**WELWYN HATFIELD BOROUGH COUNCIL
EXECUTIVE DIRECTOR - PLANNING, PUBLIC PROTECTION AND GOVERNANCE**

DELEGATED APPLICATION

Application No: 6/2018/1520/HOUSE
Location: 171 Parkway Welwyn Garden City AL8 6JA
Proposal: Erection of single storey rear extension
Officer: Ms Louise Sahlke

Contract	PROPOSED EXTENSION		PROPOSED GF PLAN		REV.	
	171 PARKWAY		Scale	Date	Drawn	Checked
	WELWYN GDN CITY, HERTS, AL8 6JA		1:75	06.2018		
Title				Drawing Number	Revision	
			MP-04

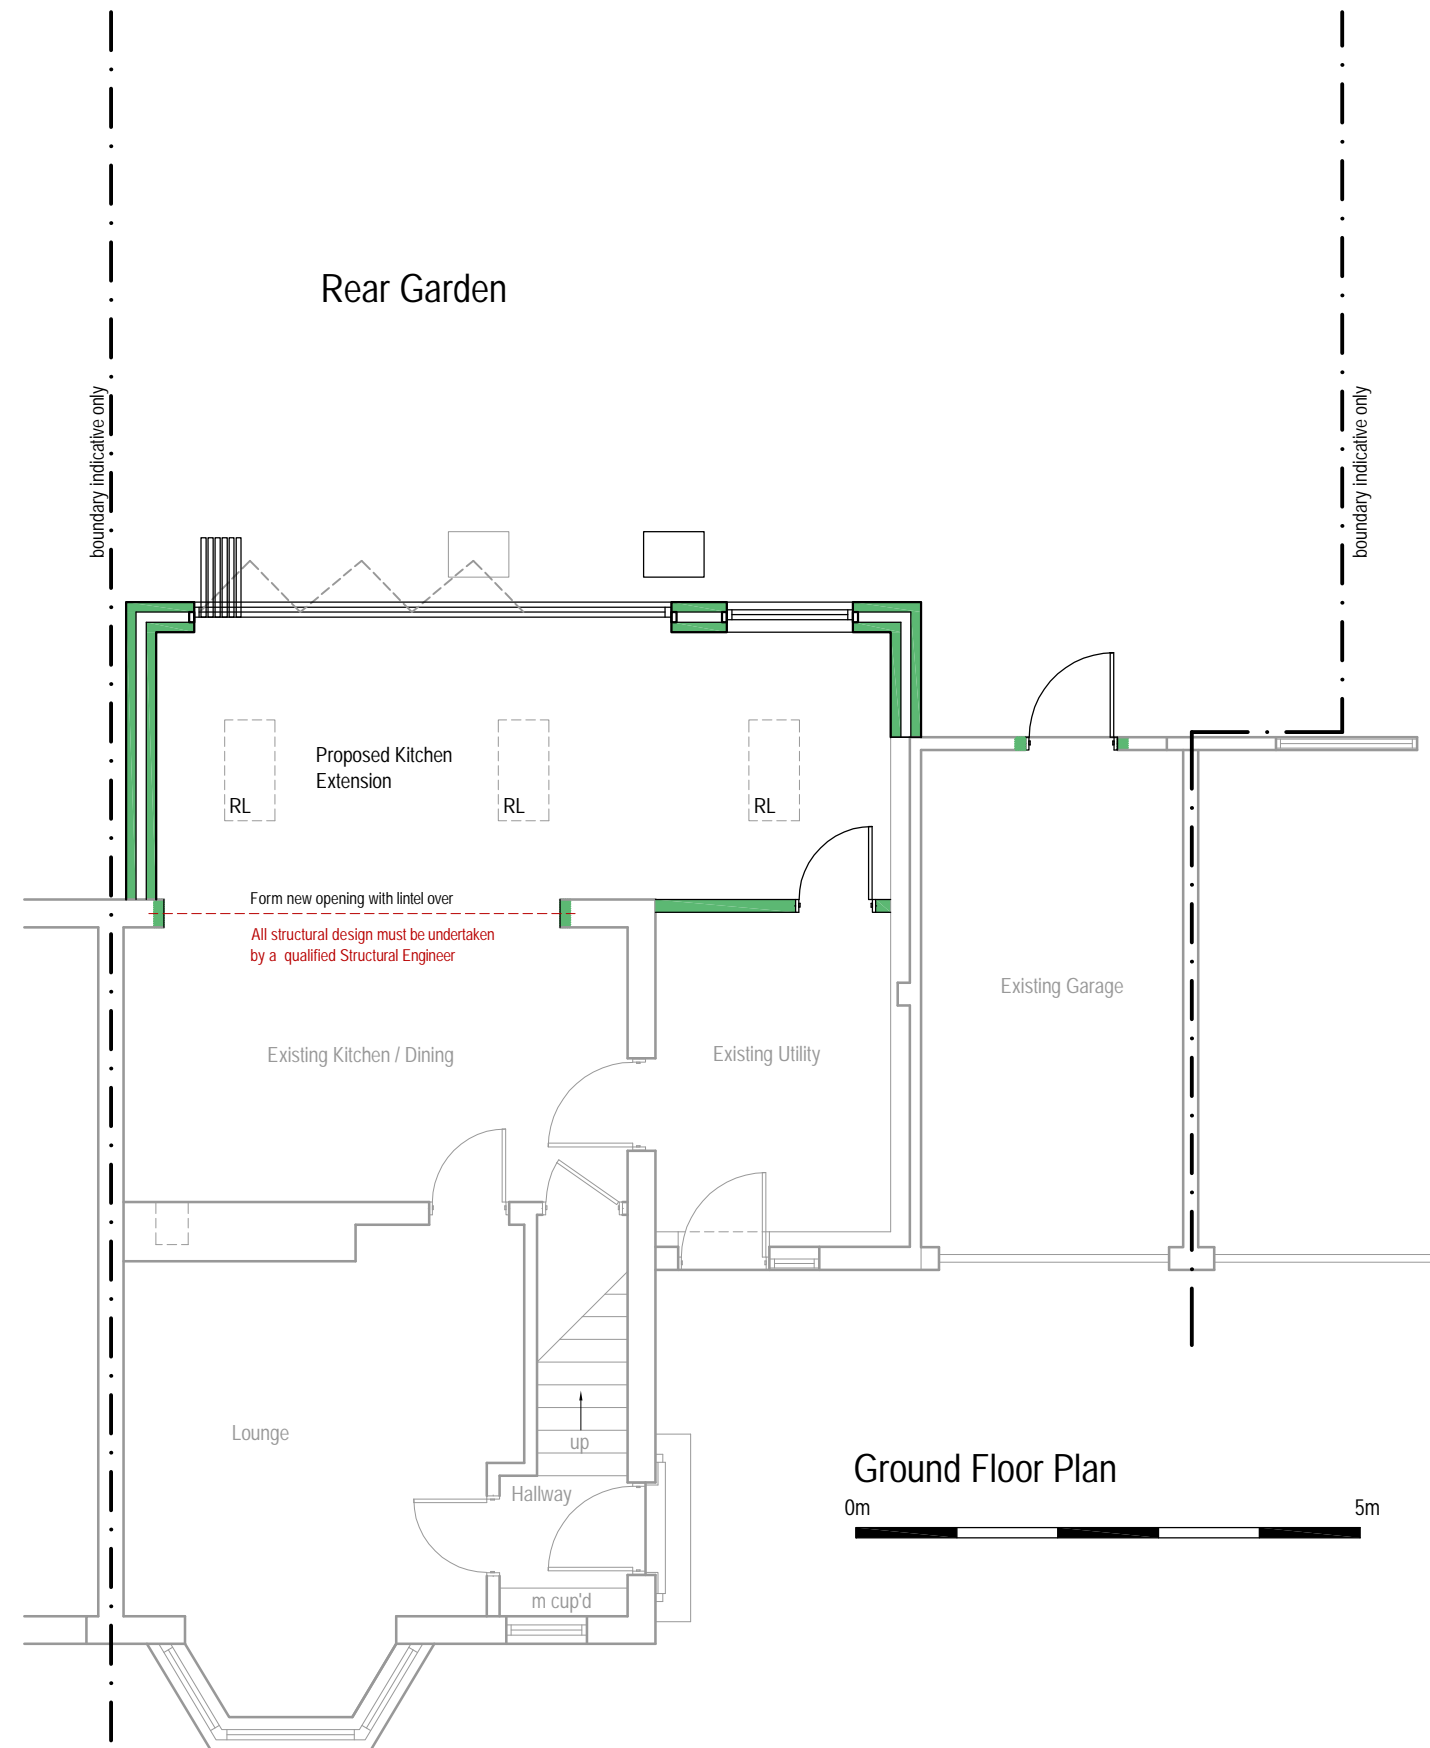
The proposal is not considered to result in a loss of privacy. There are no side windows in the proposed rear extension.

Concerns are raised by the Case Officer in regards to the main habitable ground floor window at 169 in regards to a loss of daylight, sunlight and outlook. In order to determine the loss of daylight and sunlight to extensions, a BRE 45 degree assessment was used to determine the harm between properties. A 45 degree line is drawn both vertically and horizontally. There are no rear extensions at 169 Parkway. Therefore there is a breach of the 45 degree line as drawn vertically on plan view.

Therefore based on the above assessments, it is not considered that the level of daylight and sunlight to 169 Parkway would be sufficient to warrant a refusal.

Contract	PROPOSED EXTENSION		PROPOSED ELEVATIONS		REV.
	171 PARKWAY				Scale
	WELWYN GDN CITY, HERTS, AL8 6JA		Title		1:100
					Date
					06.2018
					Drawn
					Checked
					Revision
					MP-05

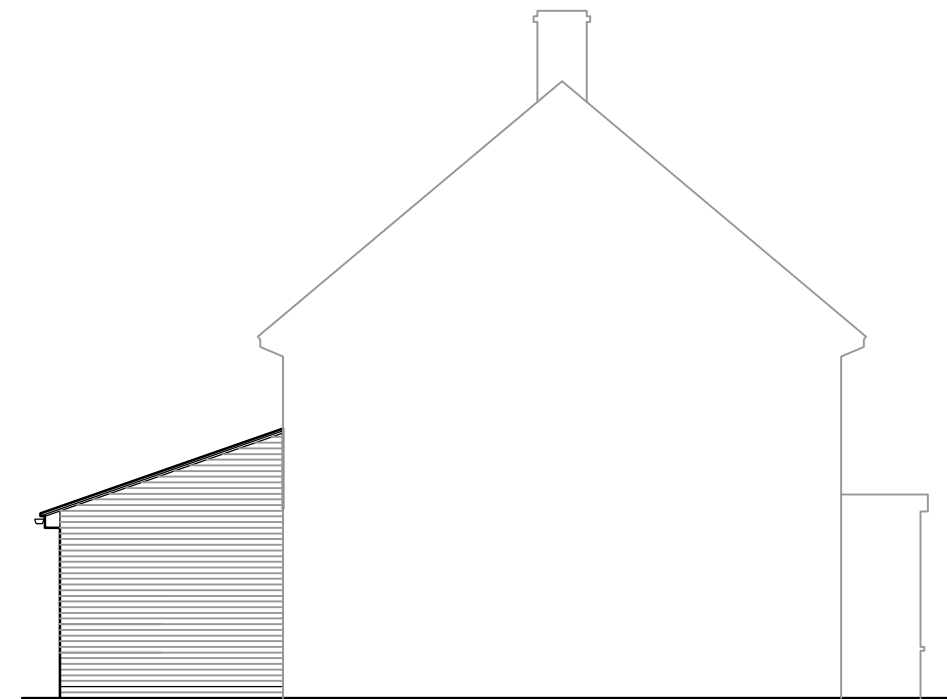
The proposed development by virtue of the scale, height, bulk and design of the proposed development is considered acceptable.

A 45 degree line is drawn vertically from the top of the roof towards the ground floor rear window at 169 Parkway on elevation plan. The results of these tests are that there would additional loss of daylight and sunlight to the existing ground floor window over and above that of the existing situation. However, the tests demonstrate that there would not be a total loss of daylight or sunlight to the existing window. Furthermore, there would be some existing loss of daylight and sunlight caused through the position of the existing fence.
